DRB CASE ACTION LOG - BLUE SHEET

Project #: 1005410 Application #: 12DRB-70158
 Project Name: Richfield Park
 Agent: Forstbauer Surveying Co LLC Phone #:

PLANNING DEPARTMENT
DEVELOPMENT AND BUILDING SERVICES
TRANSPORTATION SECTION

SITE PLAN FOR BUILDING PERMIT

SITE PLAN FOR BUILDING PERMIT

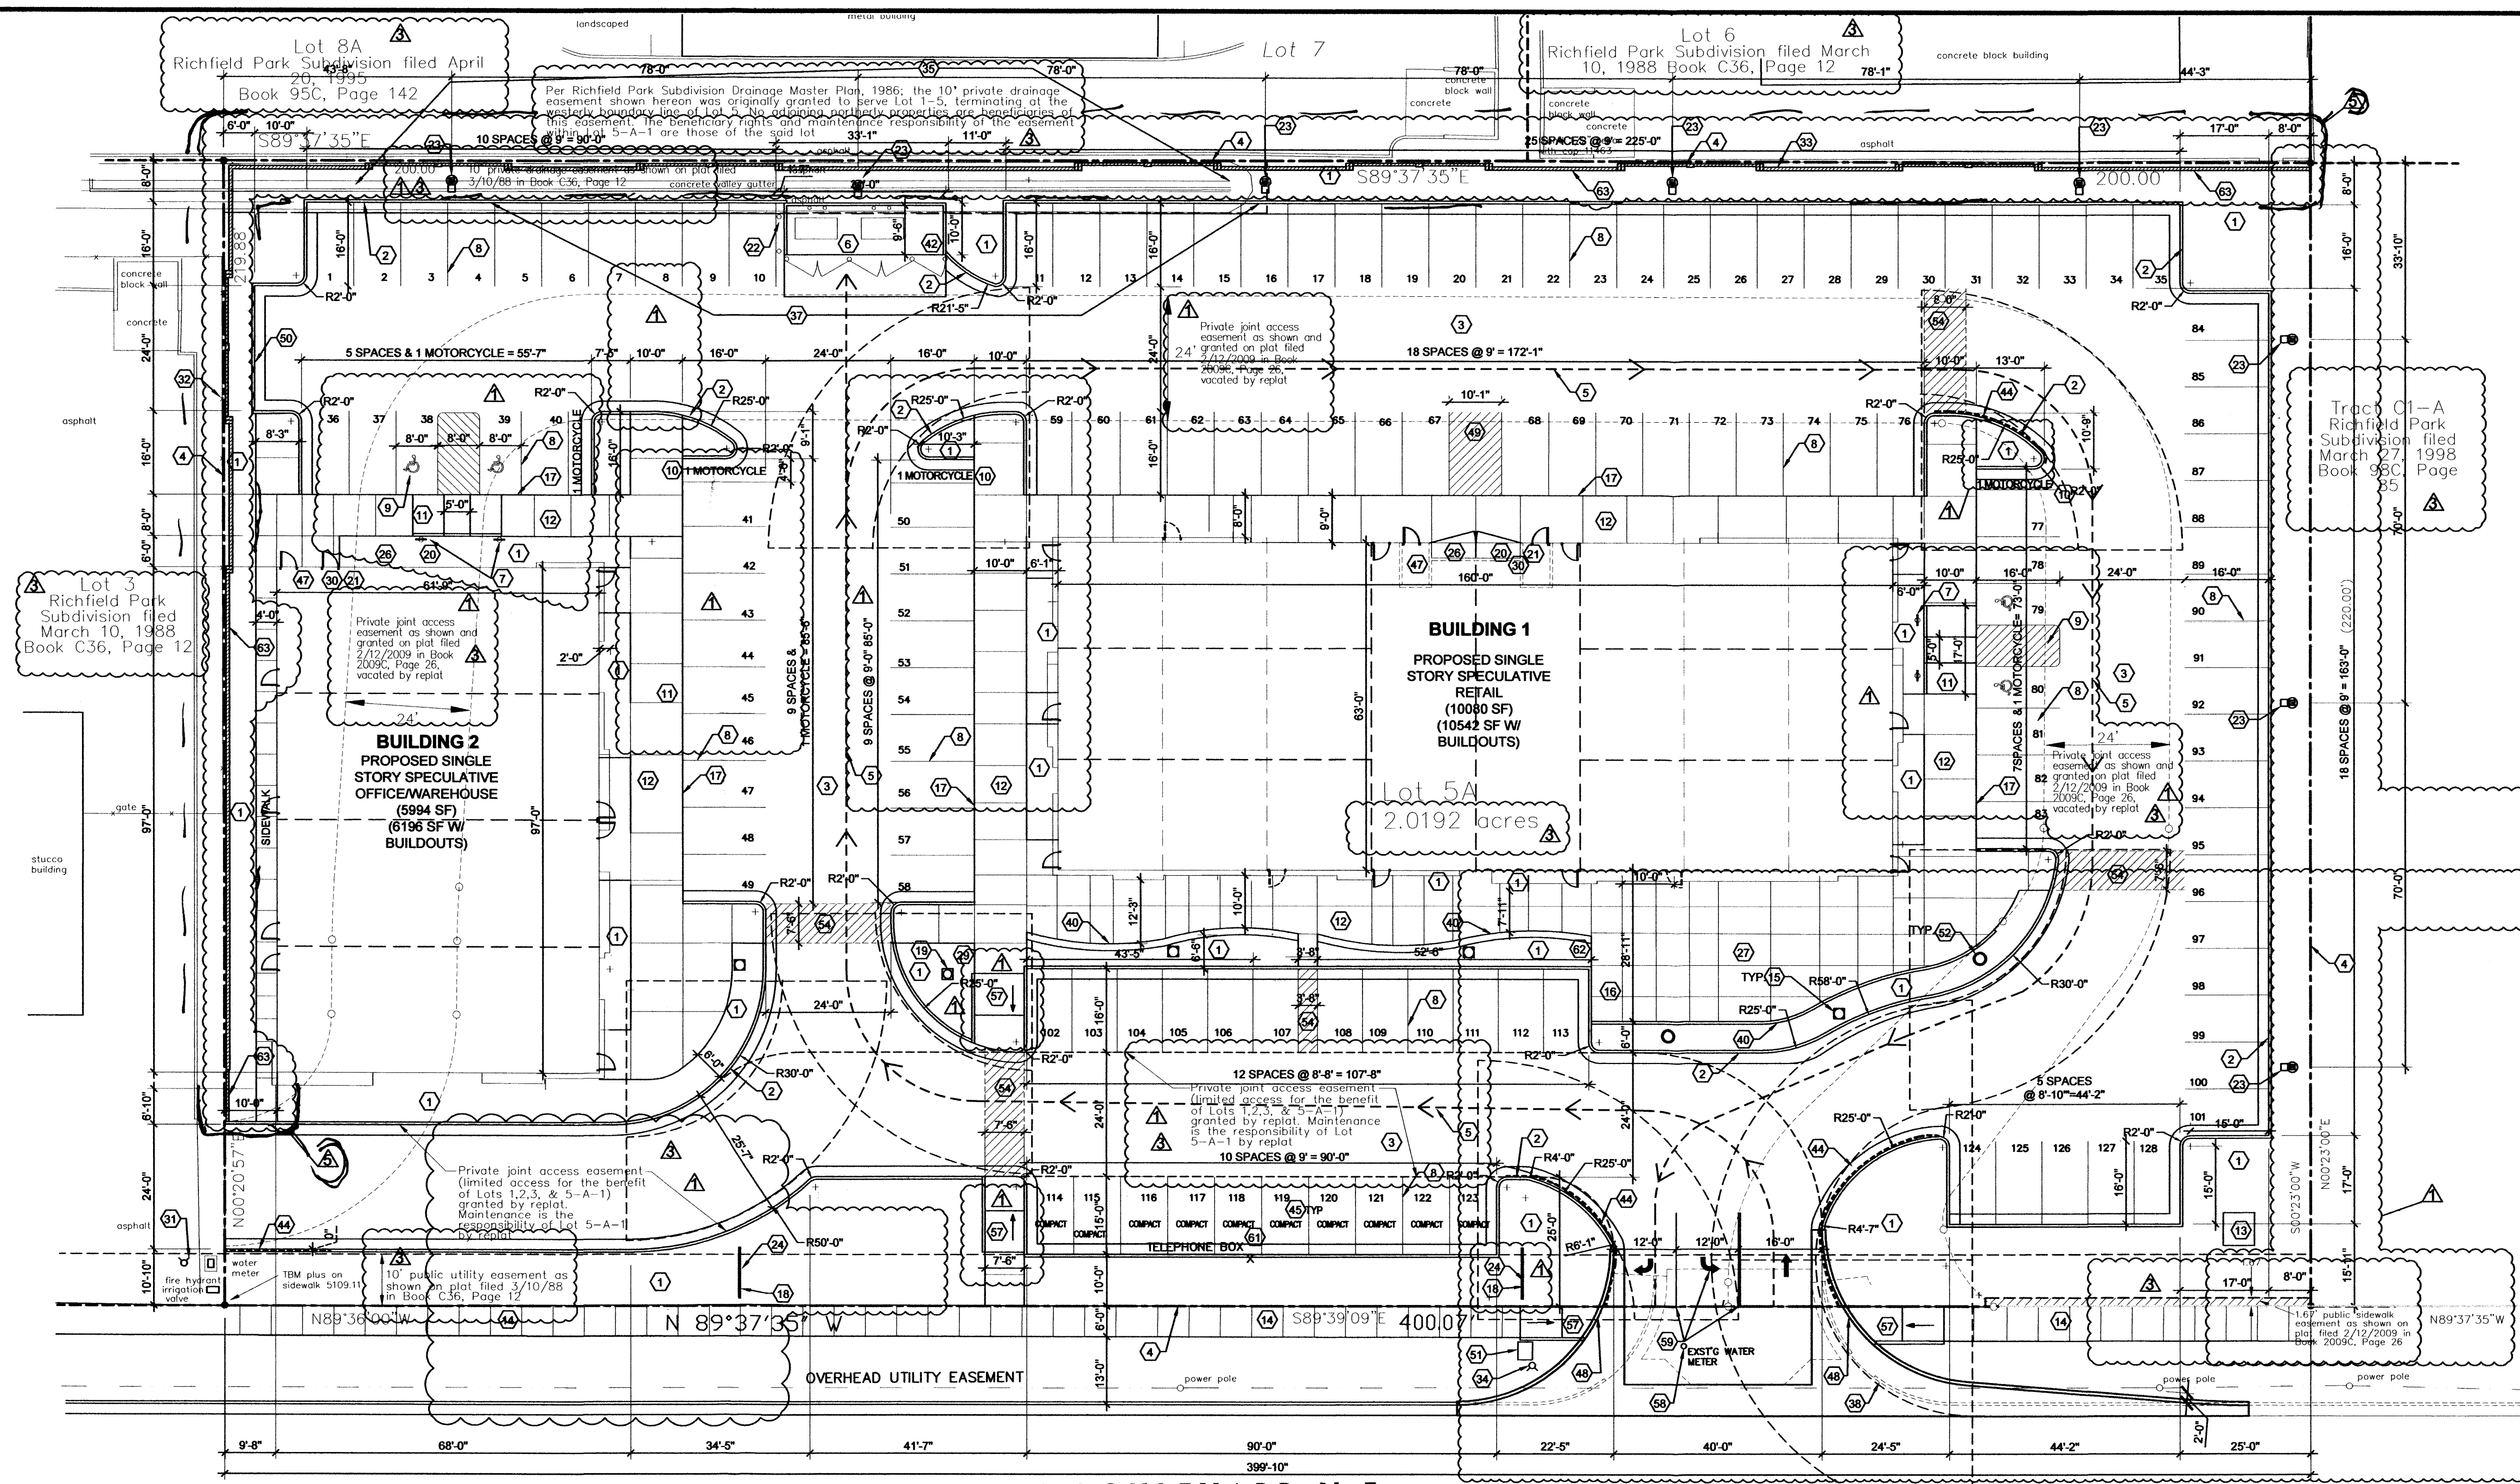
The existing joint access easement (recorded Feb 12, 2009) must be vacated prior to placing a building over a portion of the easement.

The proposed joint access easement must be provided prior to site plan approval. Provide recording information (date of recording, book, and page).

Lot 5-A
being a replat of
Lots 4 & 5

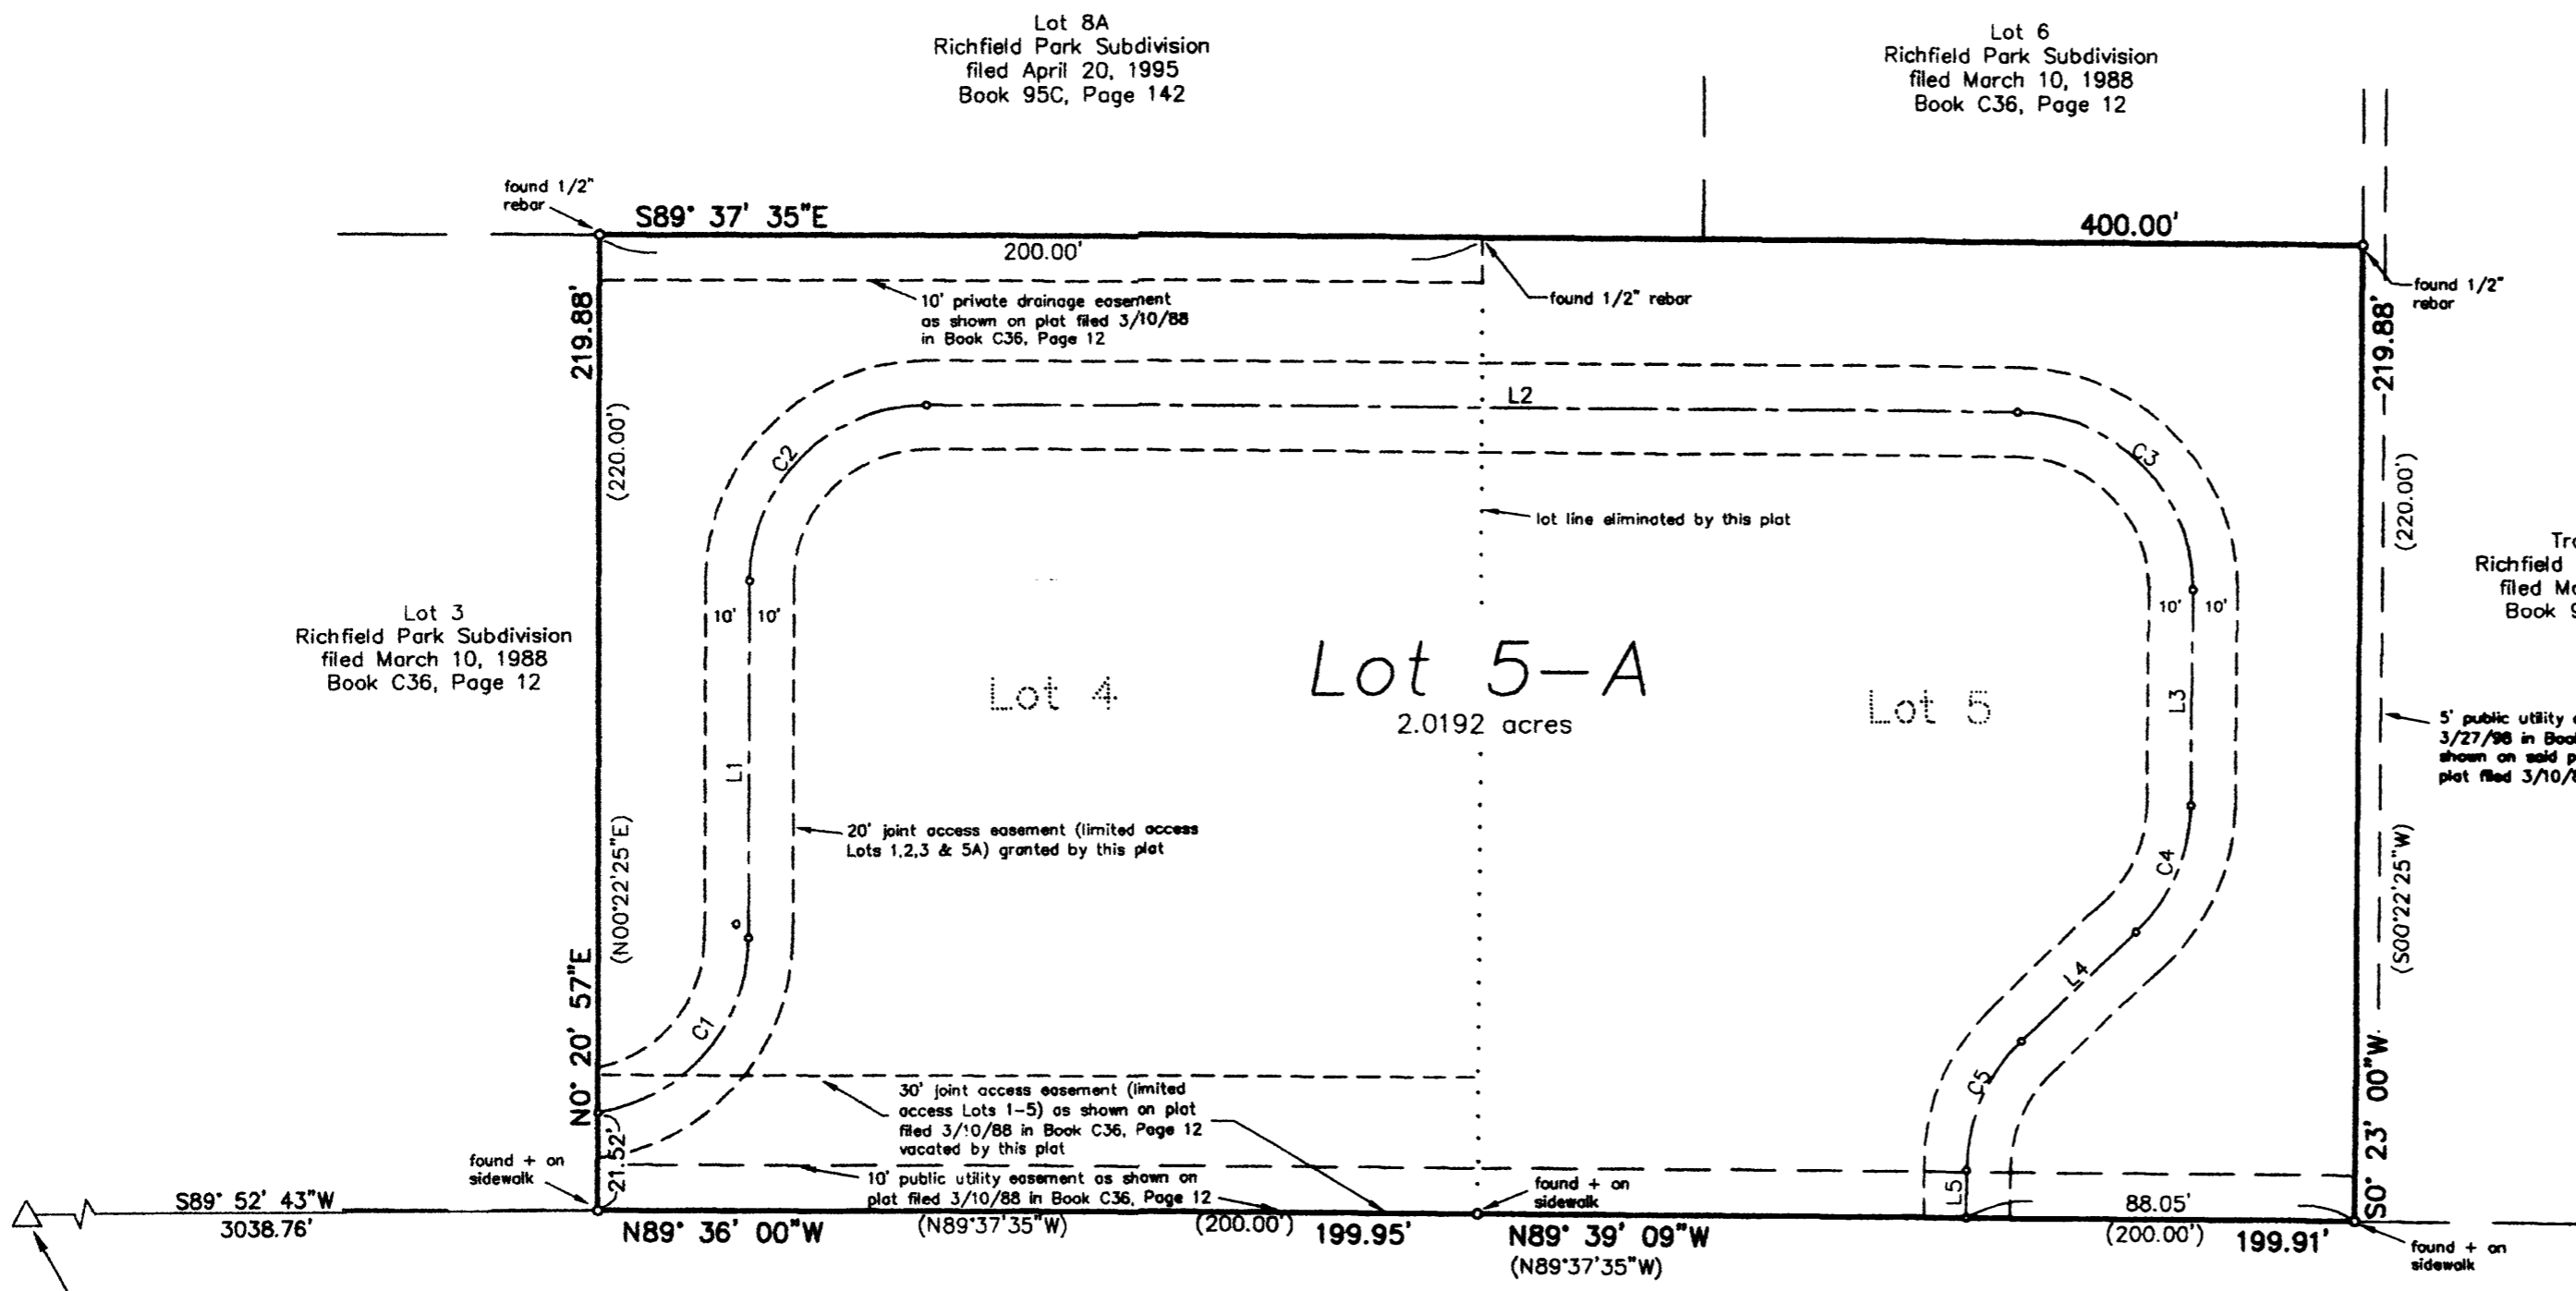
CITY ENGINEER / AMAFCA: OK clarify easement
